CITY OF ALBUQUERQUE

June 18, 2015

**Re: Alice Townhomes, 5600 Alice NE
Request For Permanente C.O. – Accepted for 60-day Temporary C.O.
Engineer's Stamp dated 5-04-13 (J18D043)
Certification Date: 6-15-15**

FIRST FLUSH REQUIREMENT
(PHASE 1)-19800 SFx.3412=561 CUBIC FEET
(PHASE 1)PROVIDED=640 CUBIC FEET

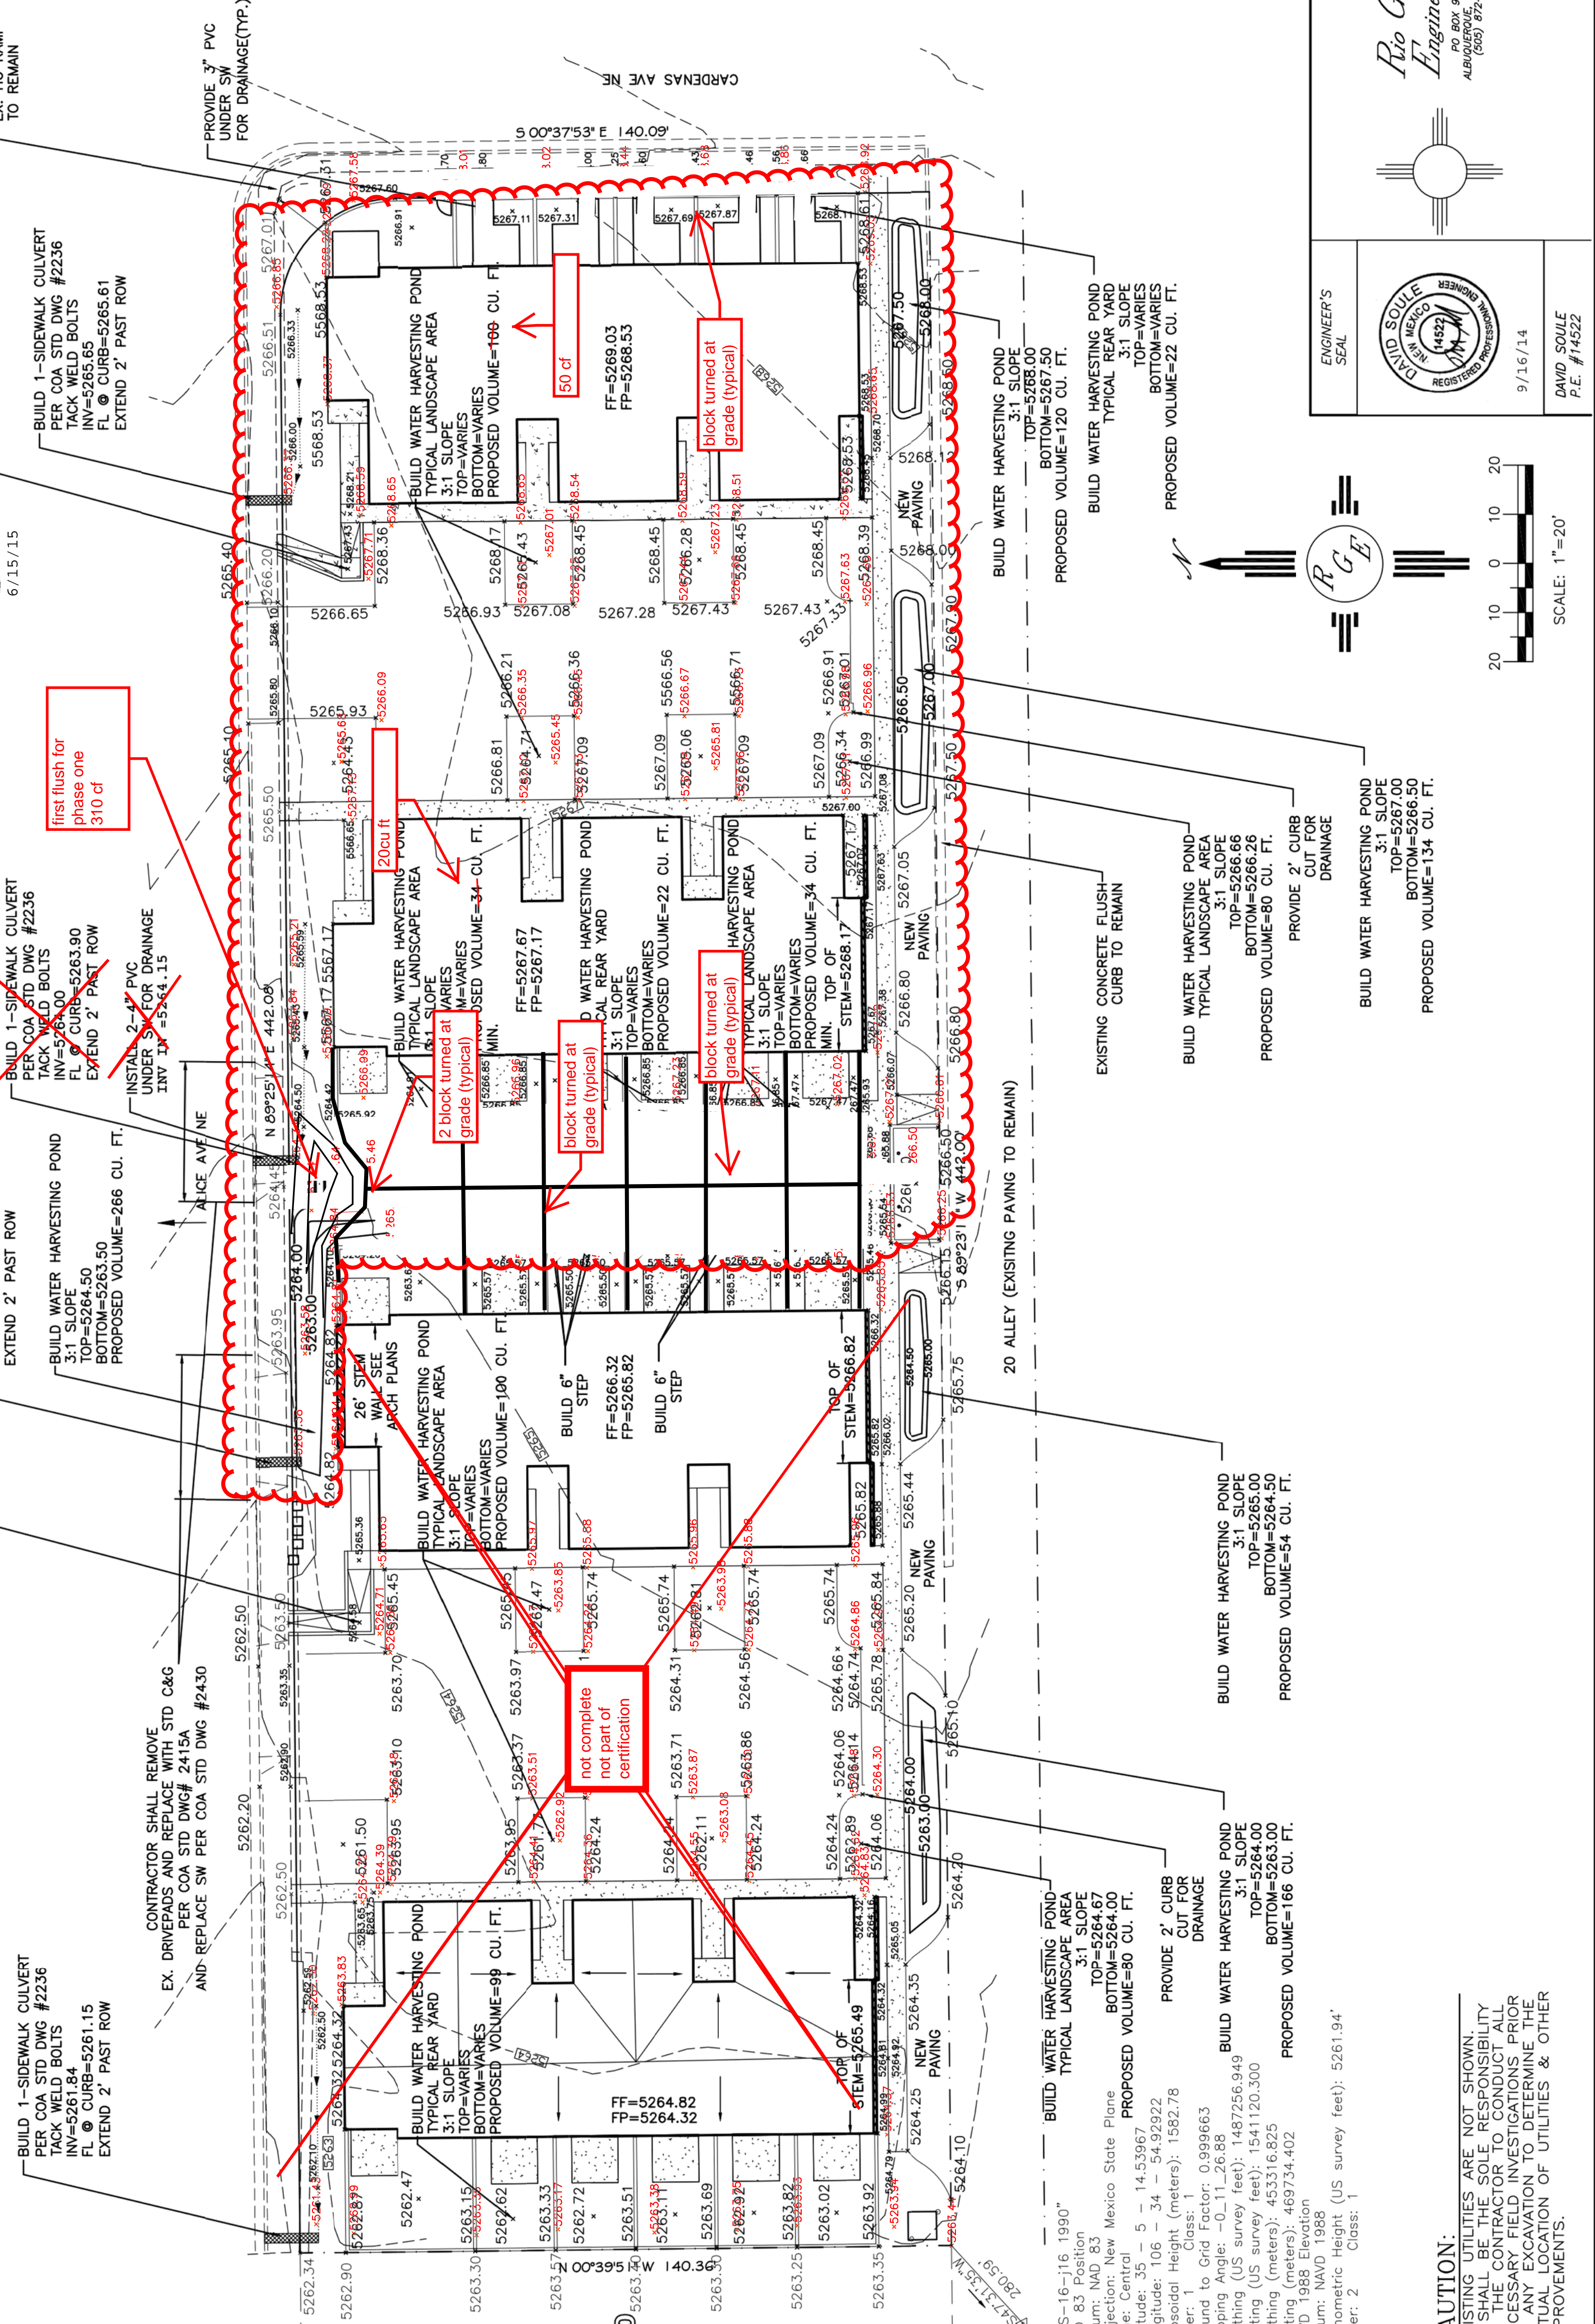
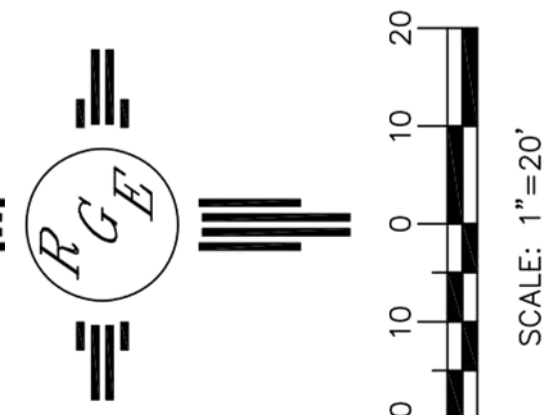
- No as-built elevations are provided for the ponds located to the south side of the buildings.
- It does not appear adequate ponding areas were created as it was shown on the grading plan (especially for the ponding area north of the building located in the middle of the project).
- Provide top and bottom areas/elevations for the pond including calculations to confirm the ponding volumes.
- An Administrative Amendment approval to the Site Plan for Building Permit is required for the changes behind the center buildings.
